# OBSERVATION/SUBMISSION TO PLANNING APPLICATION

Case Reference: 324113

**Re: Observation to the proposed development of open-cycle gas turbine (OCGT) and generator with ancillary equipment.**

Applicant: Bord Gáis Energy Limited

Purpose		PLANNING			
Title		SITE ACCESS SIGHTLINES			
Original Scale	Design/Drawn	Checked	Authorised		
SHOWN at A1	PS	ND	AJB		
Date	Date	Date	Date		
01.12.25	01.12.25	01.12.25	01.12.25		
Status	Drawing Number	Rev			
A2	PEK3-ATK-ZZ-01-DR-CE-901200	0

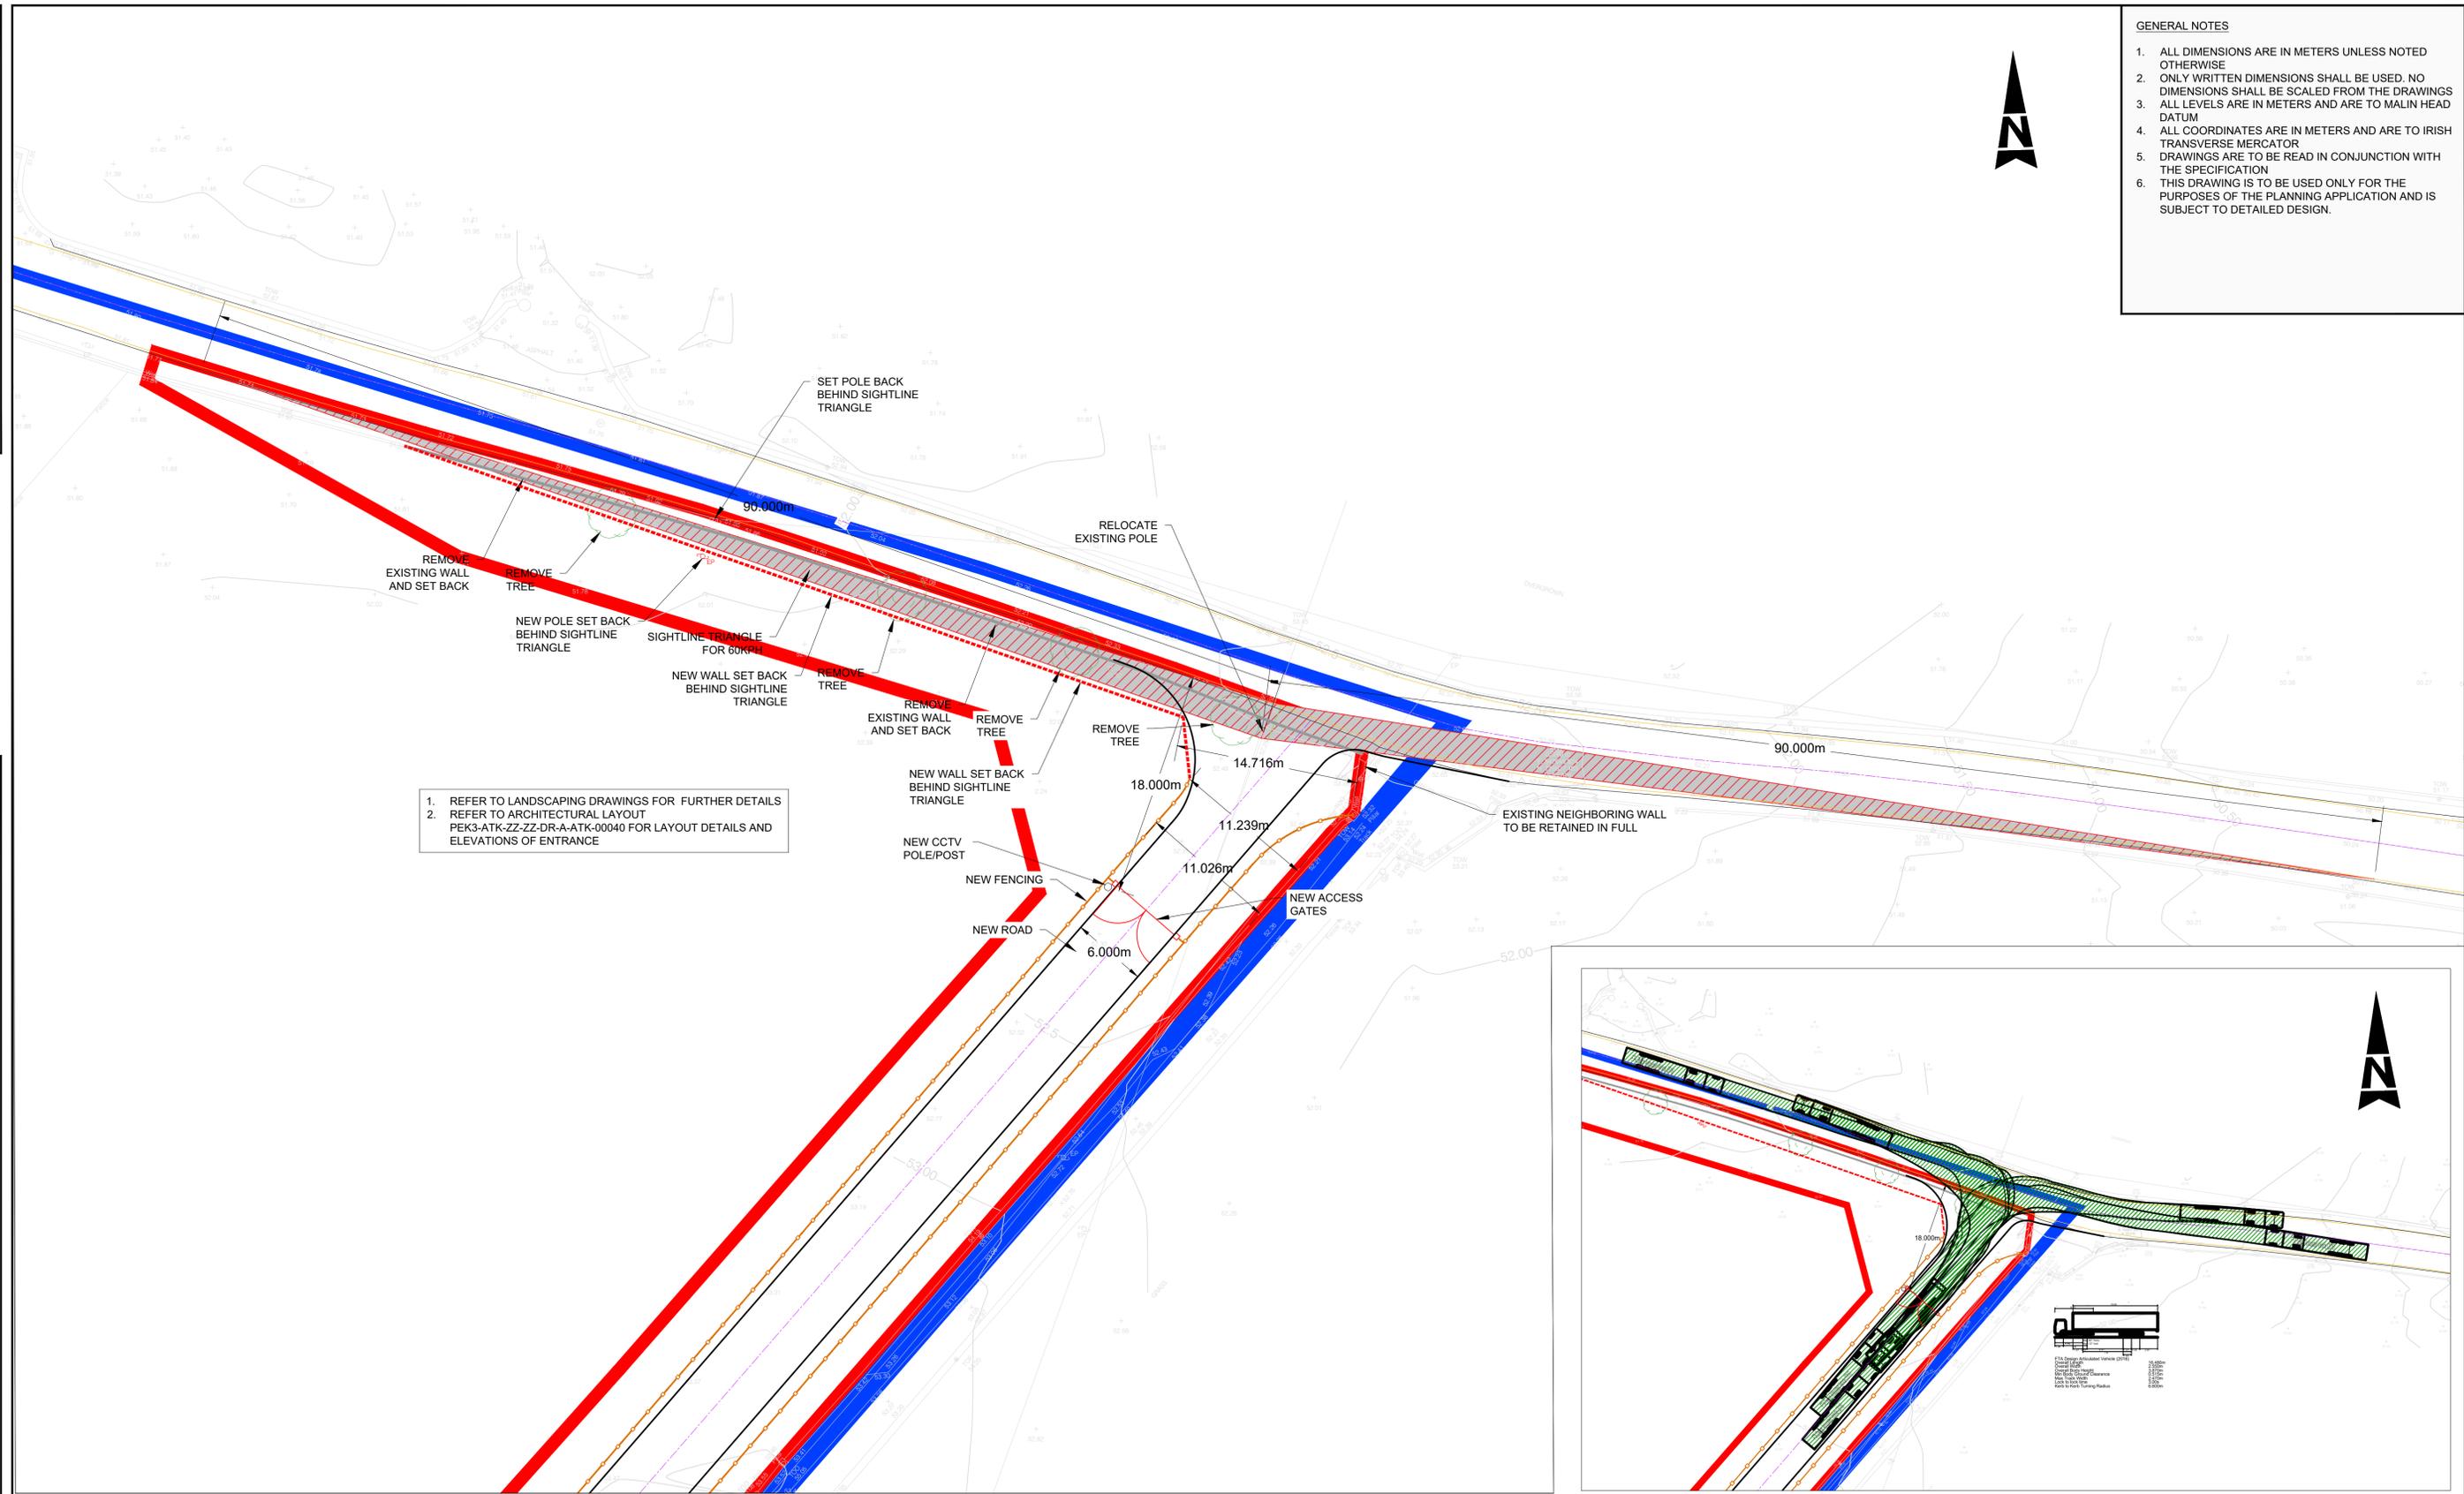
As people who live locally and use this road on a regular basis to visit our daughter, We are concerned about road safety in relation to the proposed entrance on the L3103. This stretch of road is already extremely narrow, with no hard shoulder, making it difficult for two heavy goods vehicles to pass safely and leaving no margin for error. Visibility is also poor due to blind dips and sharp bends, meaning drivers often cannot see oncoming traffic in time. The proposed development would increase traffic levels, including heavy goods vehicles, construction traffic, and fuel deliveries such as diesel tankers, all of which require space and clear sightlines that this road does not provide.

There are serious concerns about the proposed site entrance on the L3103, which is an exceptionally dangerous stretch of road where introducing an access point would create an unacceptable level of risk. The road is extremely narrow and cannot safely accommodate two heavy goods vehicles passing at the same time, there is no hard shoulder to allow for safe manoeuvring or recovery, and visibility is severely limited due to blind dips and sharp corners. These are significant existing hazards that already pose a real danger to road users, and the addition of a site entrance would further increase that risk.
